Date: 14 October 2025

ONE EARTH SOLAR FARM

RESPONSE TO EXAMINING AUTHORITY'S WRITTEN QUESTIONS 2

Appendix 1 – Response to Examining Authorities Written Questions 2

Outline Surface Water Drainage Strategy Plans

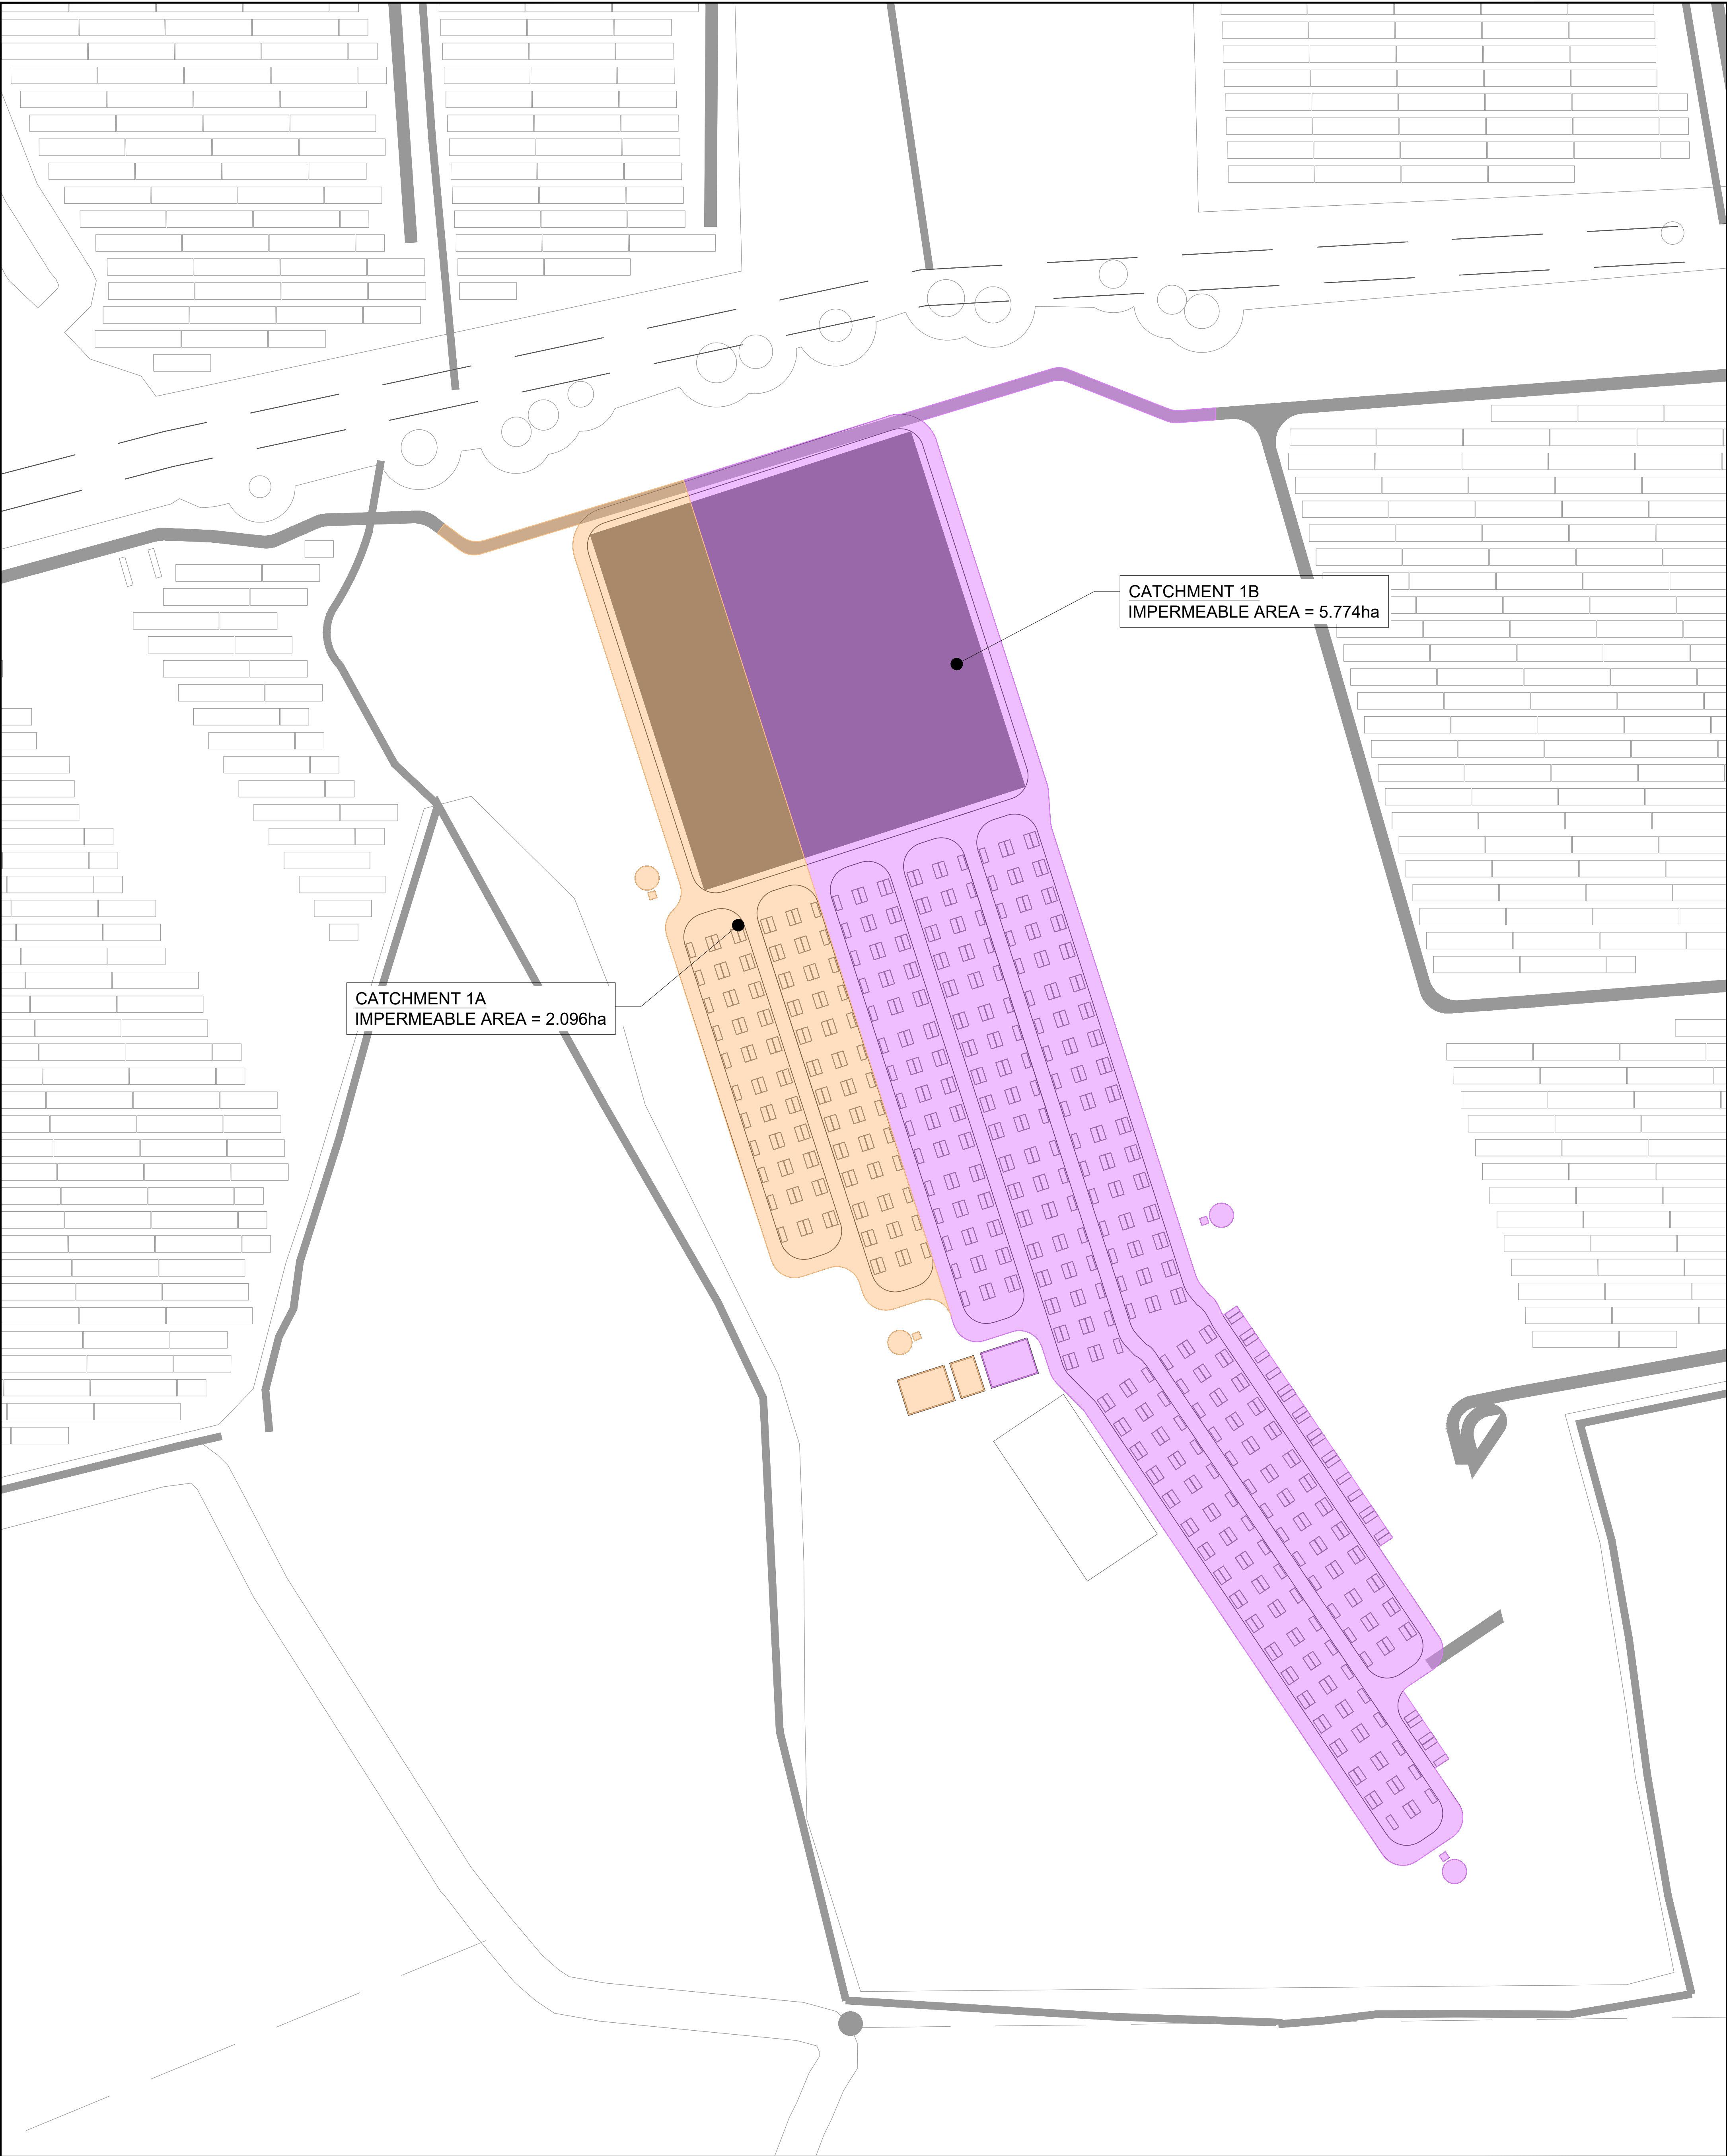
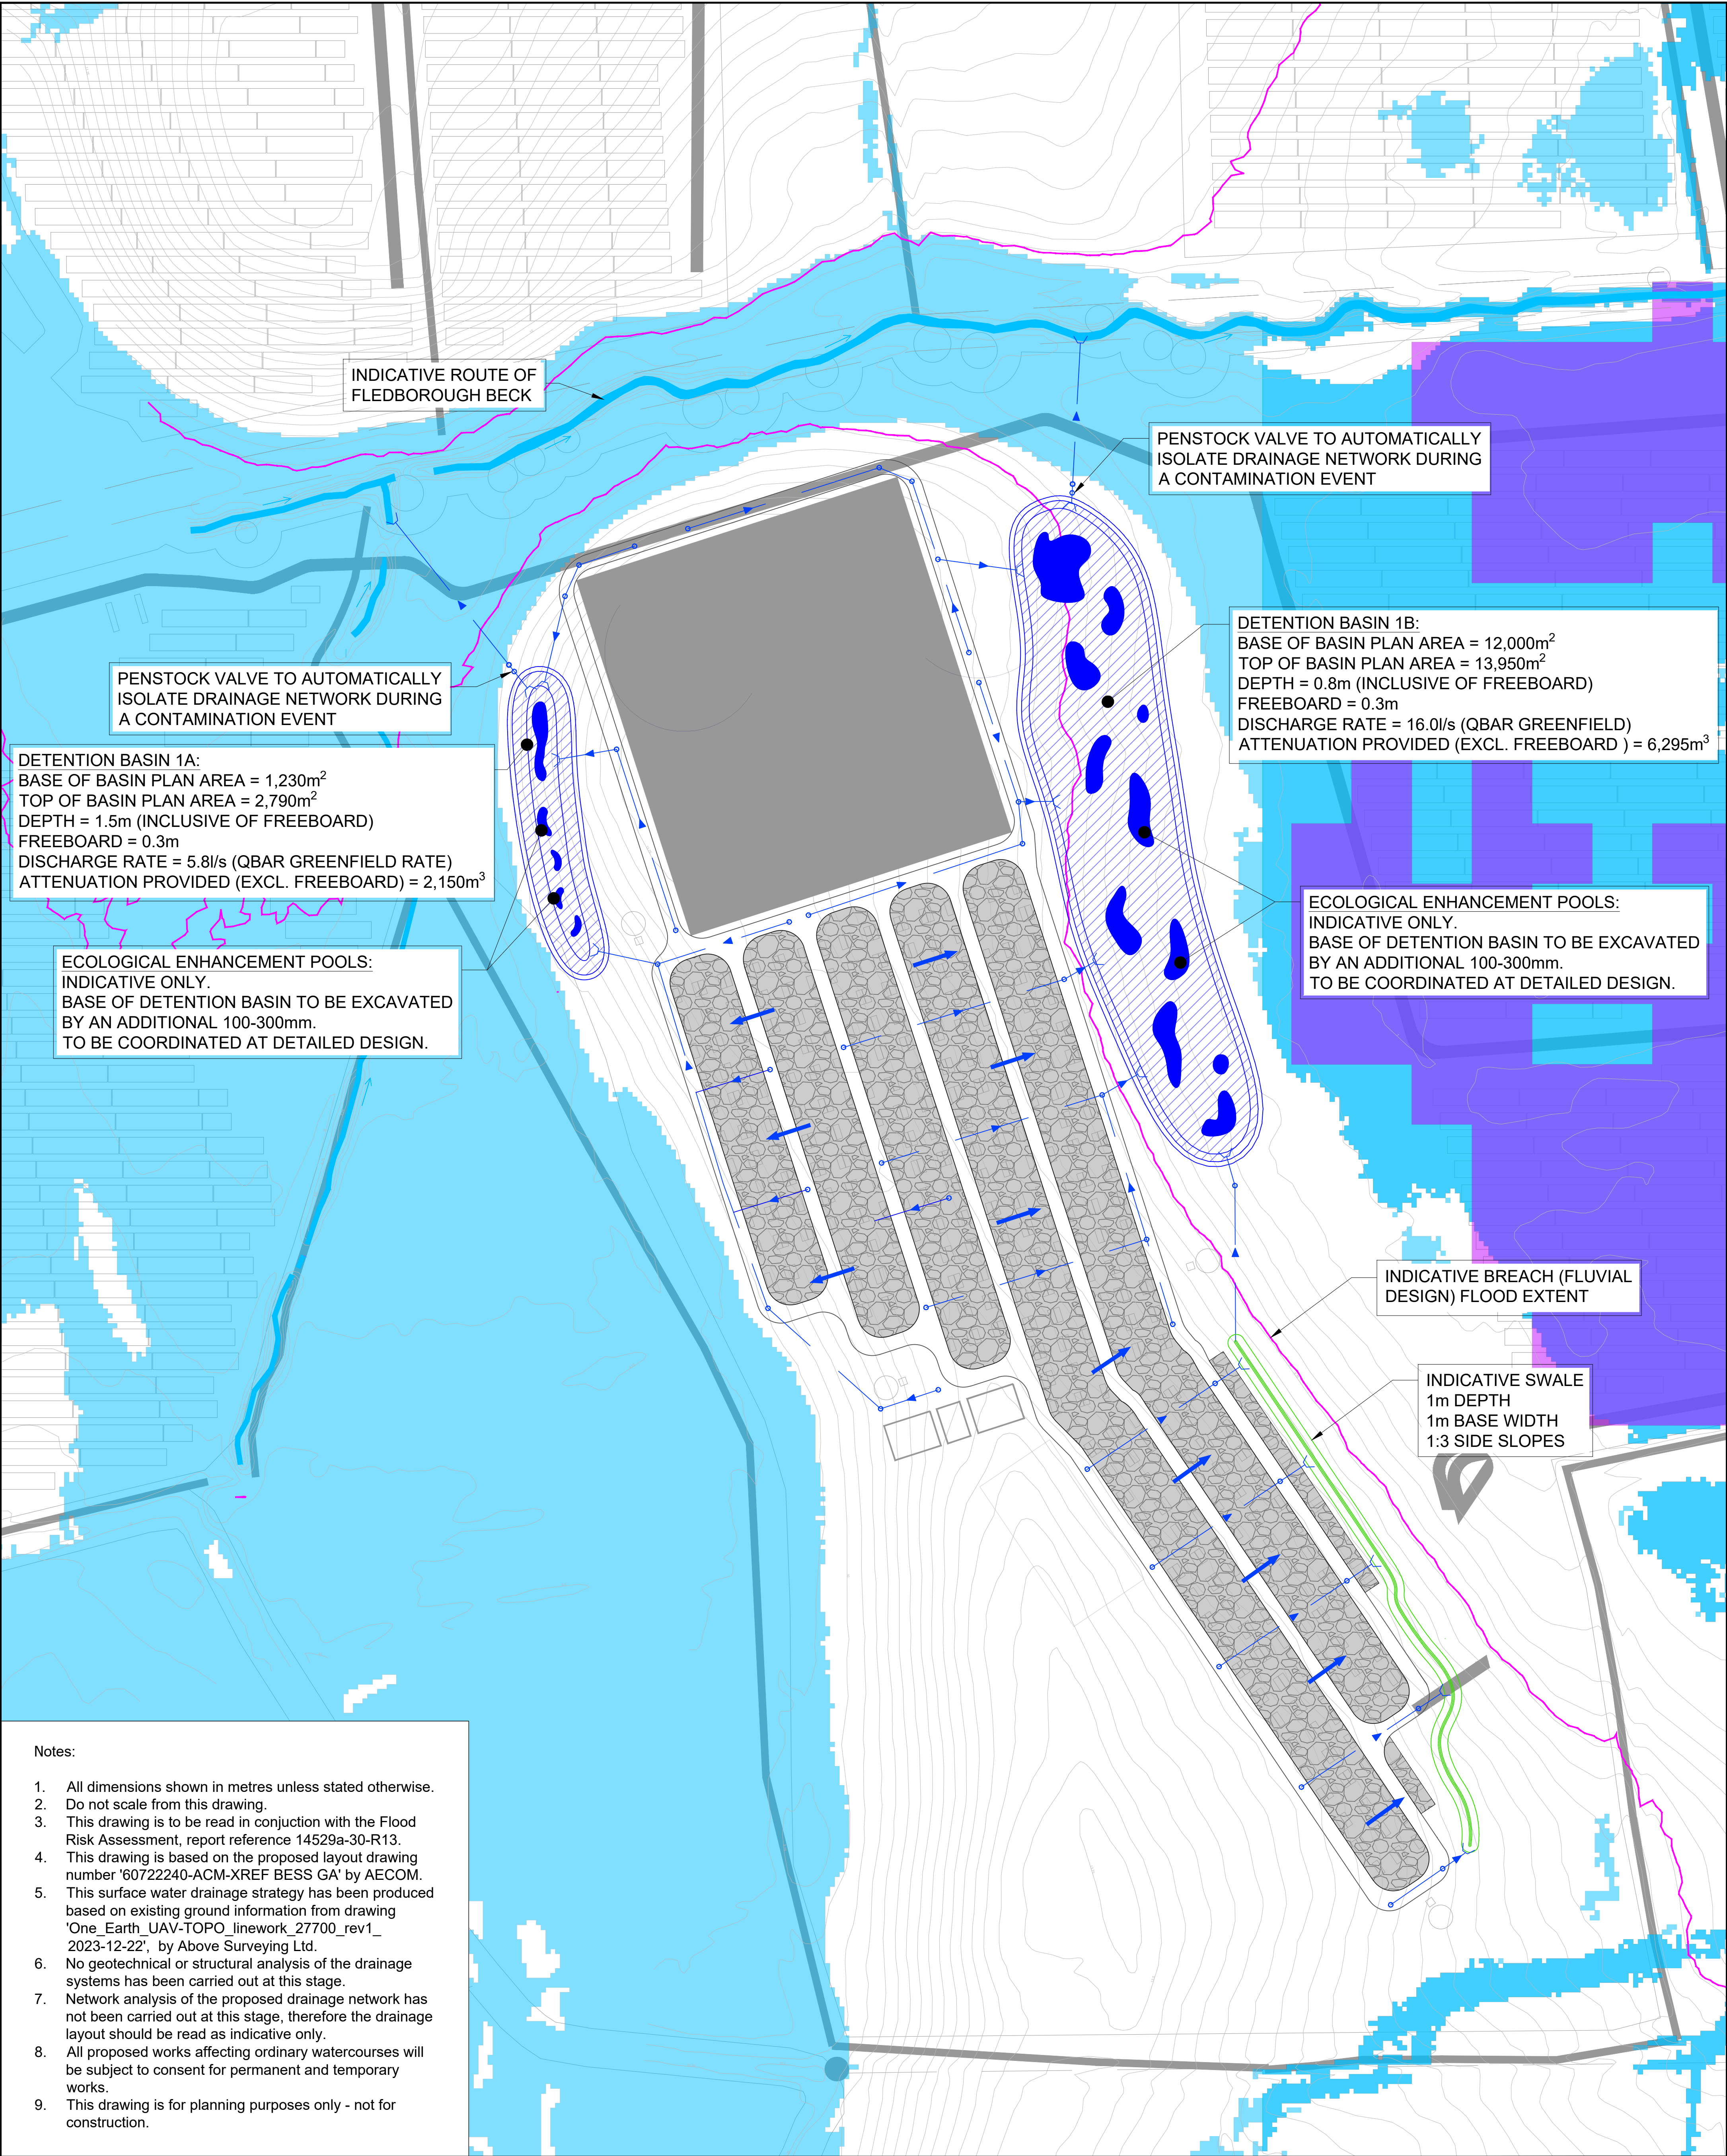
We note the concerns regarding the effects of a flood event, particularly considering the low elevation of the Eastern BESS site. We have reviewed the proposed BESS locations and the indicative drainage basin layout, as presented in the applicant's Outline Surface Water Strategy Plans (APP-017). The positioning of both the Eastern and Western BESS sites and their associated detention basins is considered acceptable from a river (fluvial) and tidal flood risk perspective. Both BESS sites are located outside of the design flood extent for the River Trent and other Ordinary Watercourses. As the development is classed as Essential Infrastructure and considering the 60-year operational lifetime of the development this is defined as the 1 in 100-year event with a higher central allowance of climate change for the 2080s epoch (2070 to 2125) which reflects a flow increase of 39%. As the BESS sites and their detention basins are outside of the design flood extent for the River Trent there is no anticipated ingress of fluvial flood water from the River Trent or other watercourses such as the Fledborough Beck into the detention basins themselves during the design flood. Furthermore, both BESS buildings are located outside of the credible maximum fluvial flood extent which is defined as the 1 in 100-year event with an upper allowance of climate change which reflects a flow increase of 62%. The detention basins associated with the BESS are also located outside of the credible maximum flood extent, the only exception to this is the northern attenuation basin in the eastern BESS site (Detention Basin 2) at grid reference 483575, 373040. Although not shown on the drainage strategy plans (APP-017) the credible maximum flood extent for the River Trent just clips the eastern edge of this attenuation basin although the associated flood depths in this area are small, generally being less than 200 millimetres. We consider this to be reasonable given the fact that this only occurs in the credible maximum scenario, covering only a small area and only to a shallow depth. With regards to the tidal flood risk to the BESS and associated infrastructure, whilst the River Trent is tidally influenced in this location, it is fluvial flood risk that provides the dominant and more conservative flood levels and extents. During large tidal events there is a large amount of overtopping and storage, particularly in the tidal Trent floodplain downstream of the M180 motorway to the west of Scunthorpe. This results in a reduced tidal influence as you move further upstream (south) along the River Trent. For context, no areas of built development fall within the 1 in 200 year tidal flood extent for the River Trent with upper climate change applied to 2121.
